Applicant: Mr J Stokes

Description: Conversion and extension of building to form apartments

Site Address: Caxton House Surgery, 53 High Street, Grimethorpe, Barnsley, S72 7BB.

0m 1m 2m 3m 4m 5m	
A Layout redesign JS 14/12	
Rev. Description By Date	
Project 53 High Street Grimethorpe Barnsley	
S72 7BB	
Drawing Title Proposed Floor Plans	
Drawing No. high/03 Rev. A Drawn by J.S. Scale 1:50@A1 Date Jul '22

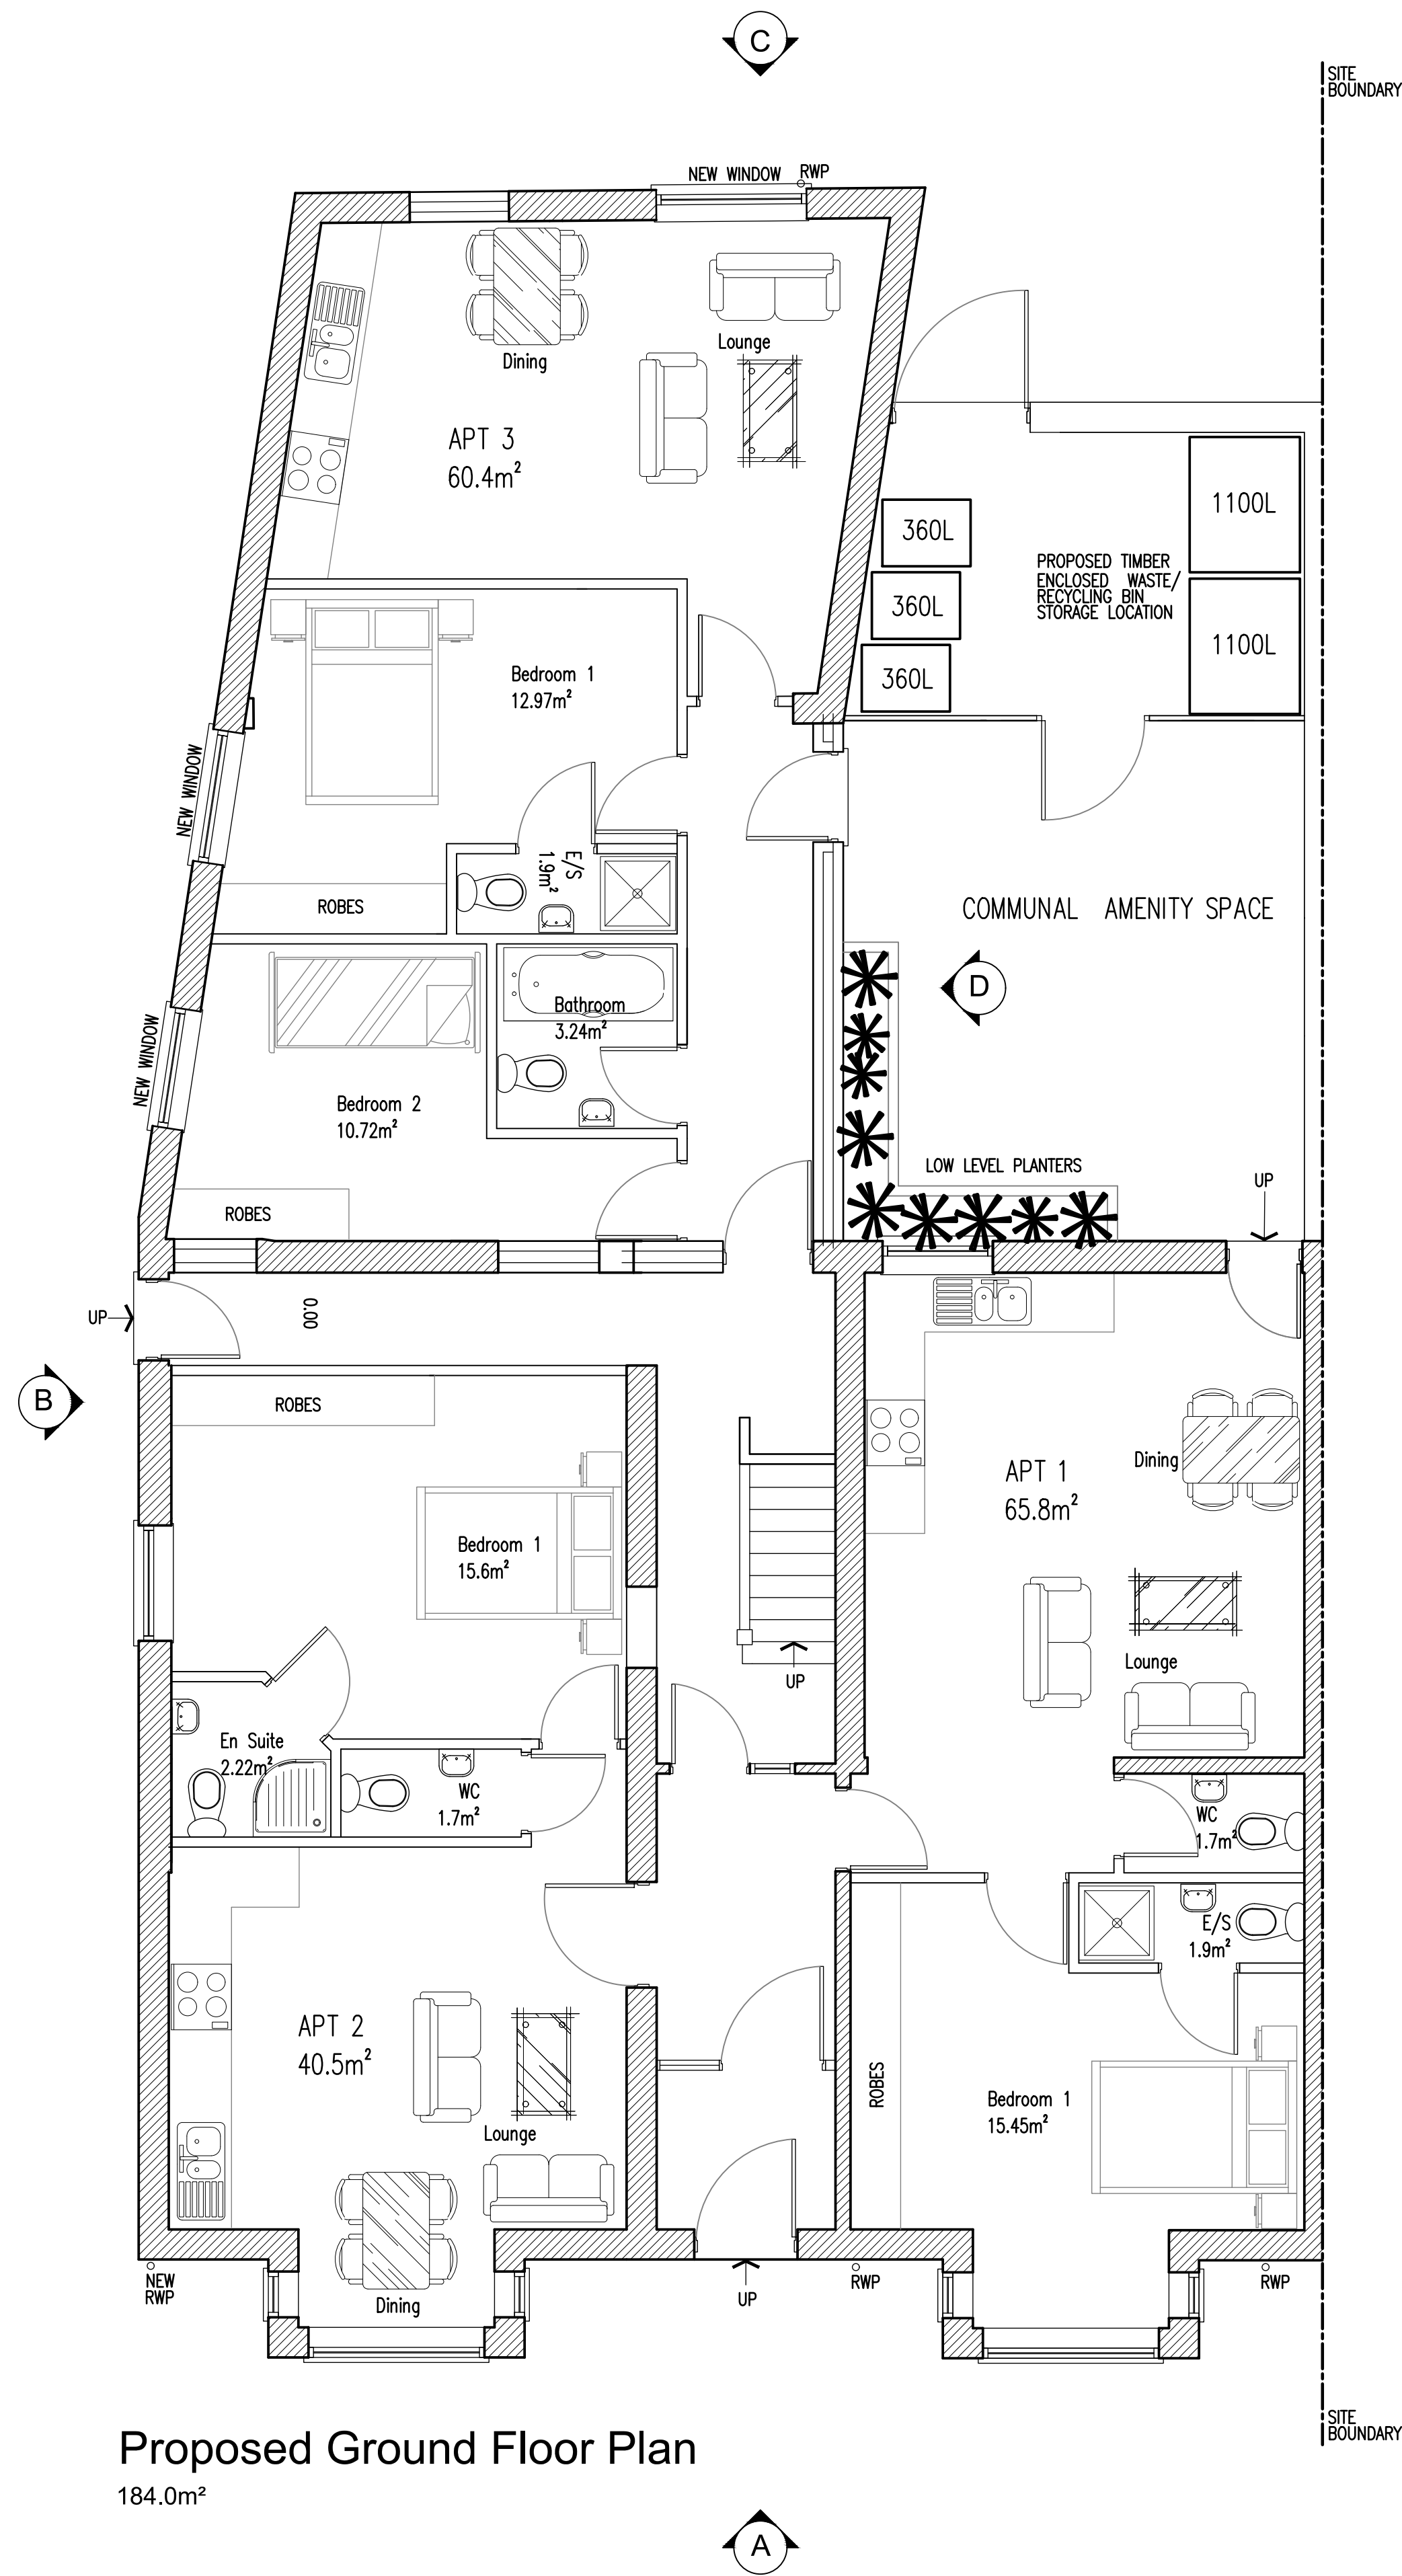
Apartment one and two are both one bed apartments at ground floor. Whilst the individual rooms meet the space standards as per the SYRDG, they both fail to meet the overall standard for a one bedroom apartment (46sqm) as they measure up at 42 and 44sqm.

Apartment three is a 2 bedroom apartment and whilst most of the individual rooms meet space standards, the en-suites are undersized and do not meet the standard of 3.5sqm and the overall standard of 62sqm is not met as the apartment measures up at 58.6sqm.

Apartment four is a one bed apartment and has an undersized kitchen/diner/lounge (KDL) at 21.3m (standard is 24sqm), an undersized en-suite at 2.21m (bathroom should be 3.5sqm) and the overall standard of 46sqm is not met as the apartment measures up at 38.19sqm.

Apartments five and six are both one bed apartments at second floor and follow a similar layout. The combined KDLs in both apartments are undersized measuring at 23.7 and 20.85sqm and the overall standard of 46sqm is not met as the apartments measure 42.4 and 39.85sqm.

All habitable room windows are served by windows which would provide a good outlook and amount of light into the apartments. The windows serving the bedrooms of apartment five and six are smaller than the other windows however this is a betterment over the rooflights over the previously refused application and the proposed elevations show that the windows will open allowing for daylight.

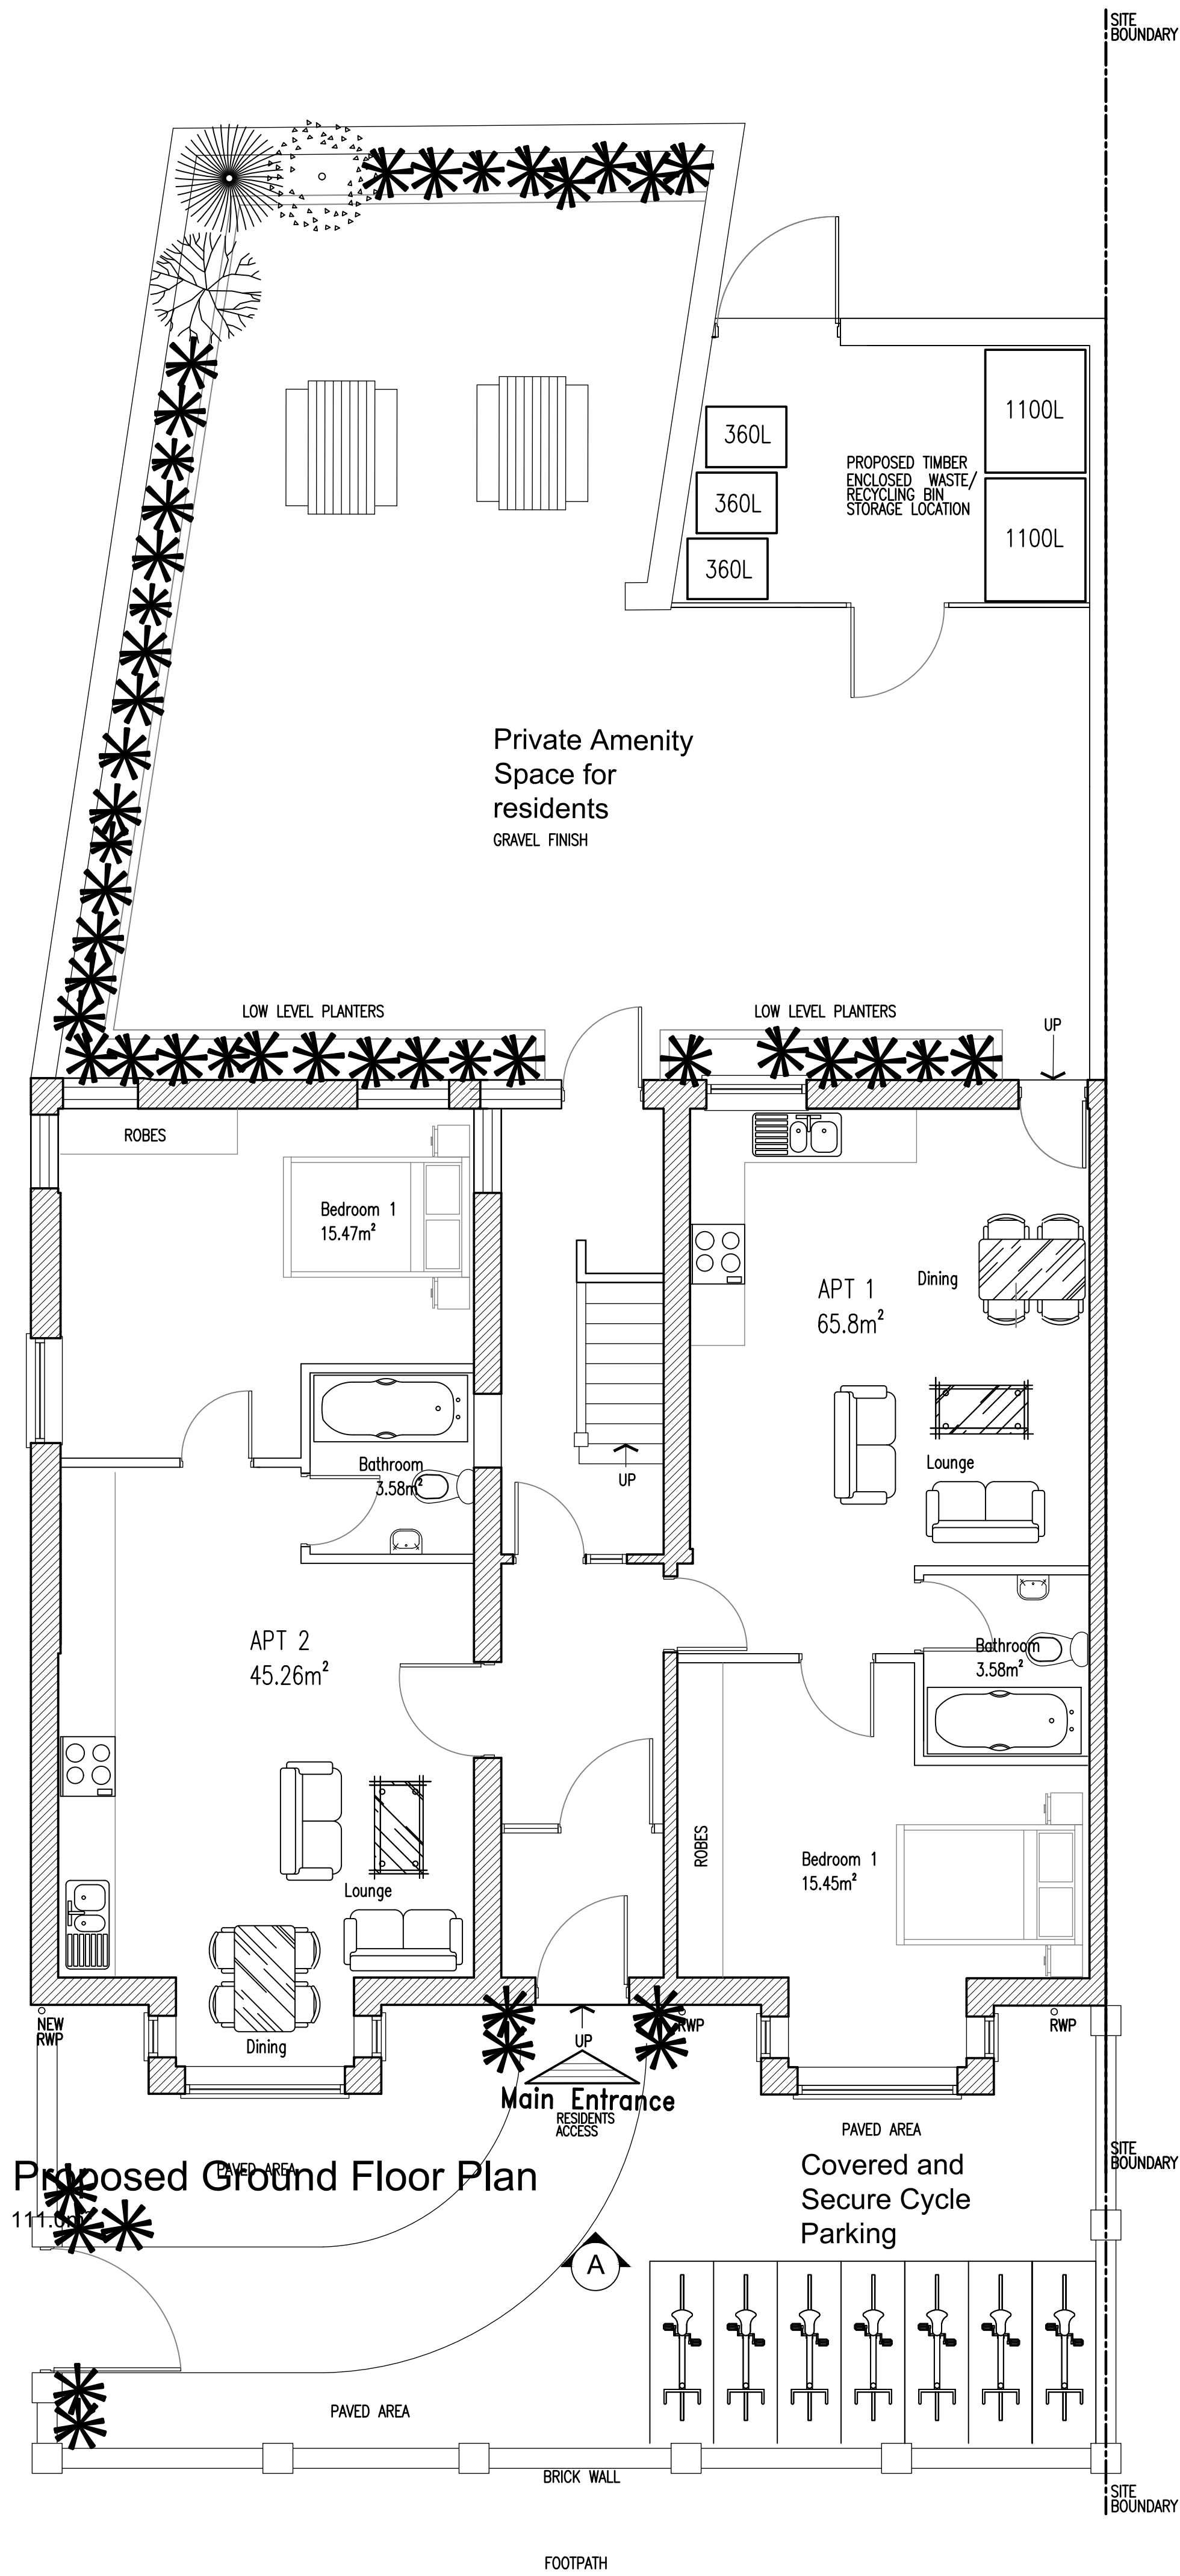
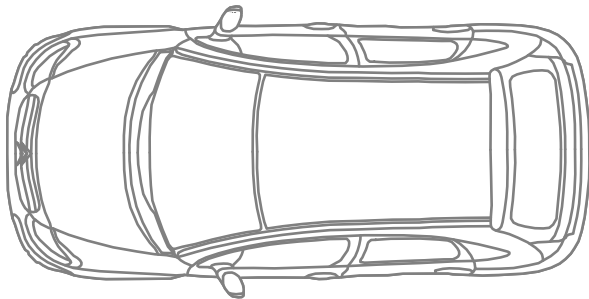
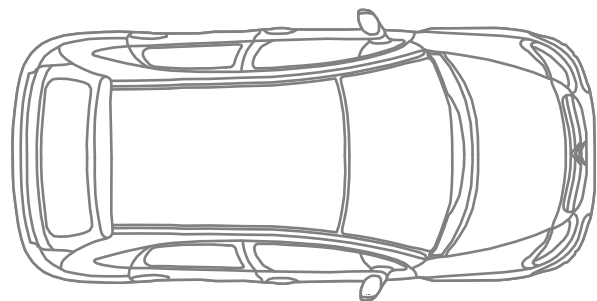
The South Yorkshire Residential Design Guide states that back gardens of houses should be appropriate to the size of the property, its orientation and likely number of inhabitants. For two bedroom houses this should be 50sqm and for three bedroom houses should be 60sqm. The guide goes on to explain that shared private space for flats must be a minimum of 50 square metres plus an additional 10 square metres per unit either as balcony space or added to shared private space. The proposed development is served by approximately 85sqm of private amenity space to the rear of the property at ground floor. This is undersized for a development of this size and should equate to 110sqm. There has been no justification given for the shortfall of 25sqm and it is considered that neighbouring properties adjacent to the site benefit from amenity space and as such this shortfall is not common of the area. As such the proposal is unacceptable from an external amenity point of view.

Barnsley SPD Parking (2019) Table 2 Cycle Parking Standards requires that 1 secure and undercover cycle parking space is provided per dwelling. 7 cycle spaces have been provided for the flats which will be acceptable but should be conditioned for retention
